Member-Secretary,  
Metropolitan  
Council Authority  
Chennai - 600 008.

Letter No. B3/10172/99

Sub: CMDA - Area Plans Unit - Planning Permission - Revised to  
~~Construction of~~ earlier road plan for the construction of  
Stilt + 4 floors (7 blocks units 112 units) residential building at Door no 1  
Thirumangalam Road, S.N. 172/24 & 172/25 of Villivakkay village  
- Remittance of DC & other charges ~~as per~~ Reg - Reg.

SCALE 1:100  
DATE 28.4.99  
JOB NO S77  
DRG CD 01  
DRW

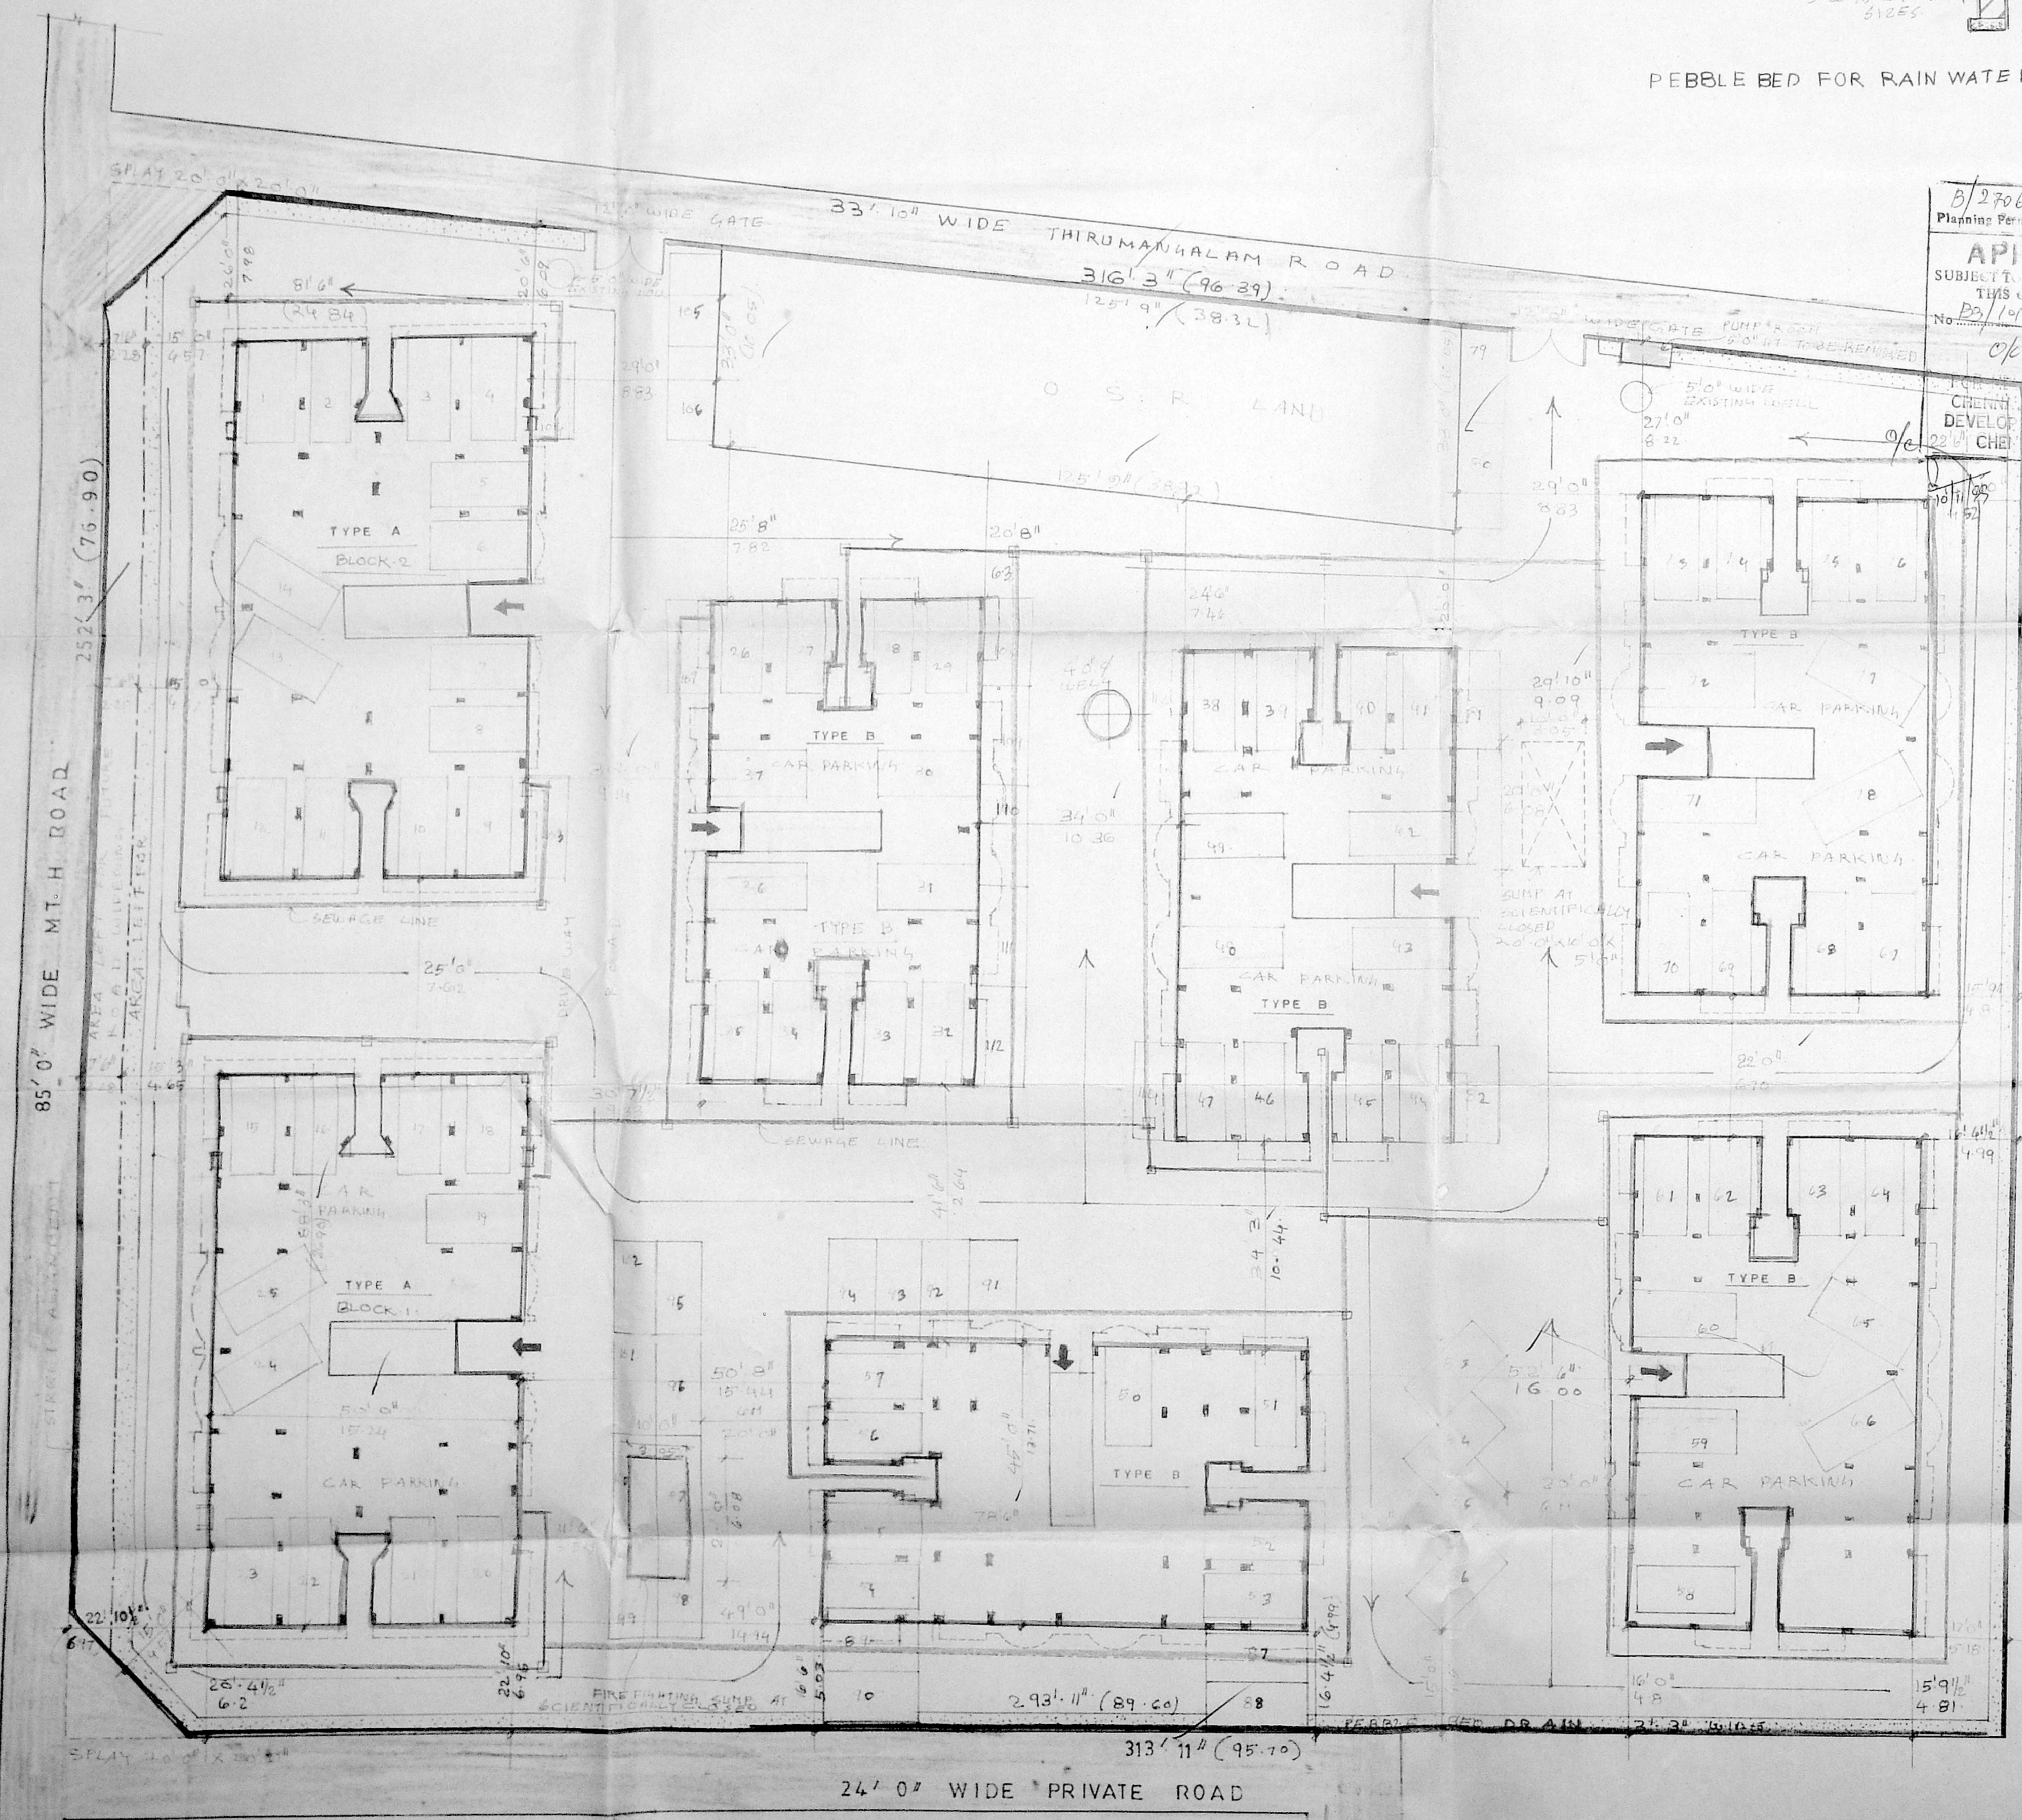
- (i) FSI restricted to 1.50, against 1.524 provided.
- (ii) Height of a Stilt floor to be reduced to 2.20m for car parking.
- (iii) Set back and building measurement to be shown as on site condition.
